RFI

RFI #: 217
Date: 1/3/2013
Job: EB-02 Keller Springs Lofts
Phone: 877-777-5115

CC: Walter Kilroy (BGO)
Subject: Details needed for concrete pole base

E-10.1

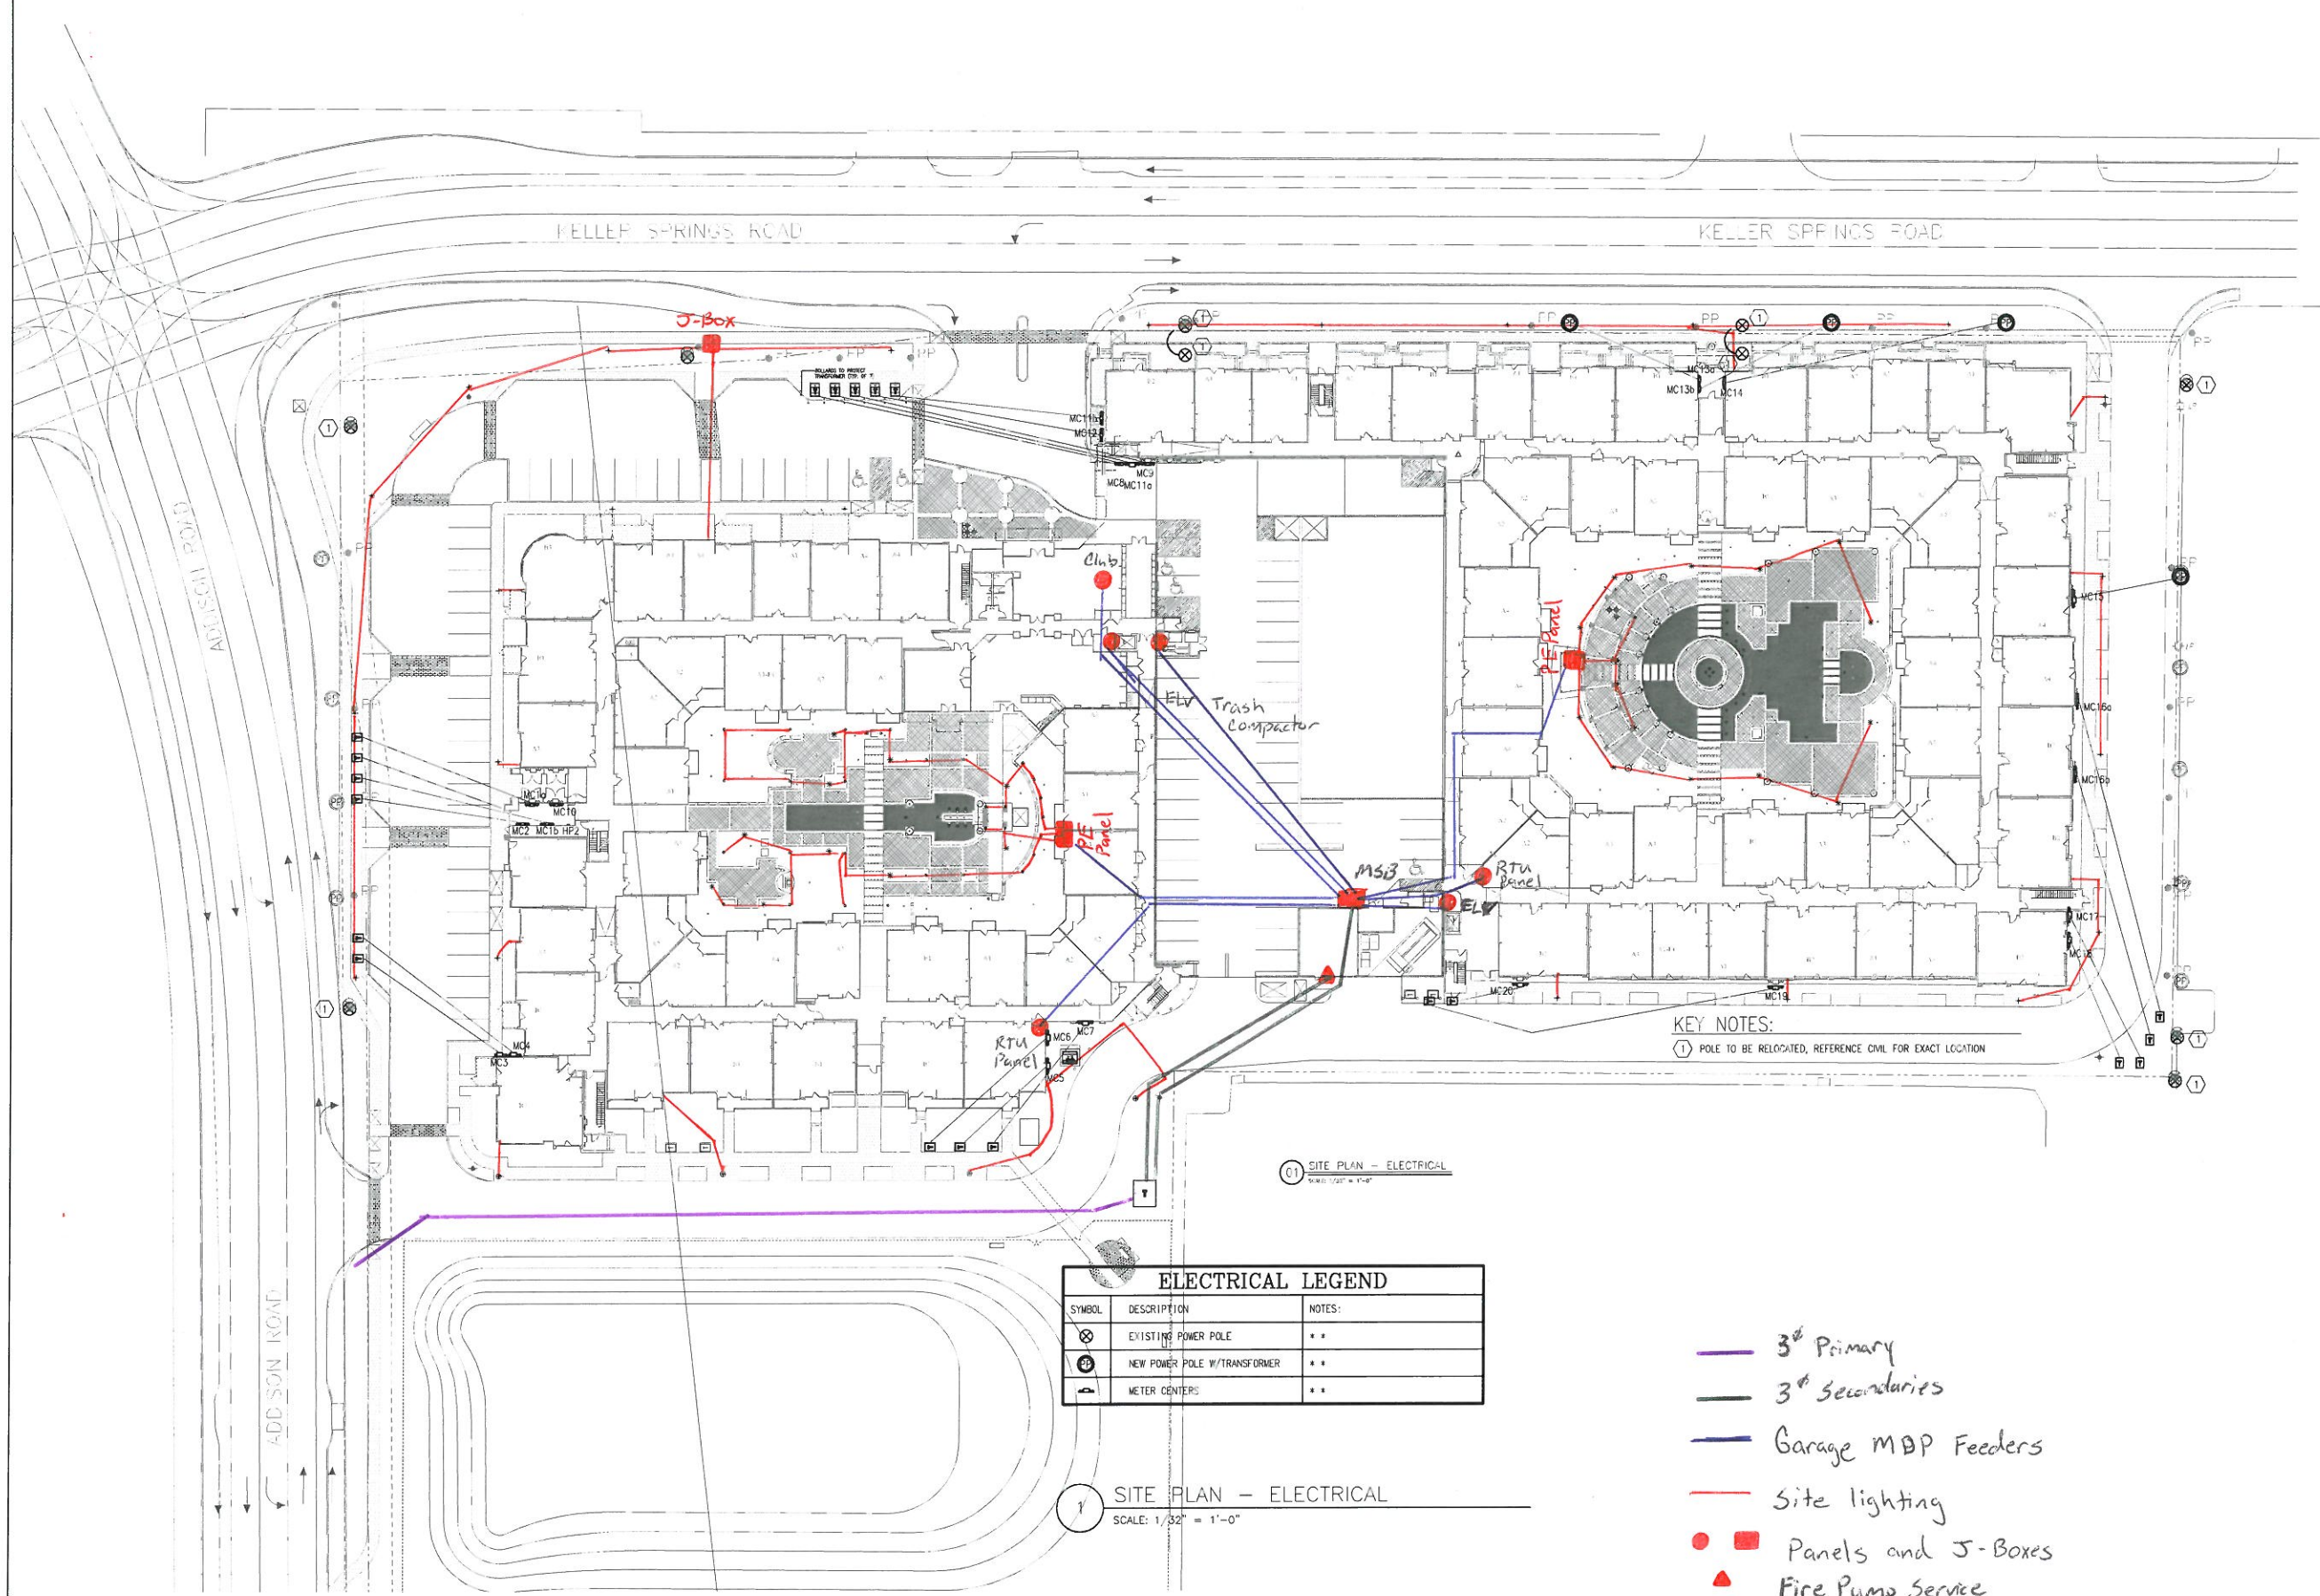
Request: **Date Required:** 1/9/2013
There is no detail for the site pole light base supports. Attached are the specs. for the poles along with the connection plate template. Please provide the concrete pole base specs. where shown on hand drawn sketch.

Response:
See attached drawing, SK-11, for the requested light pole foundation
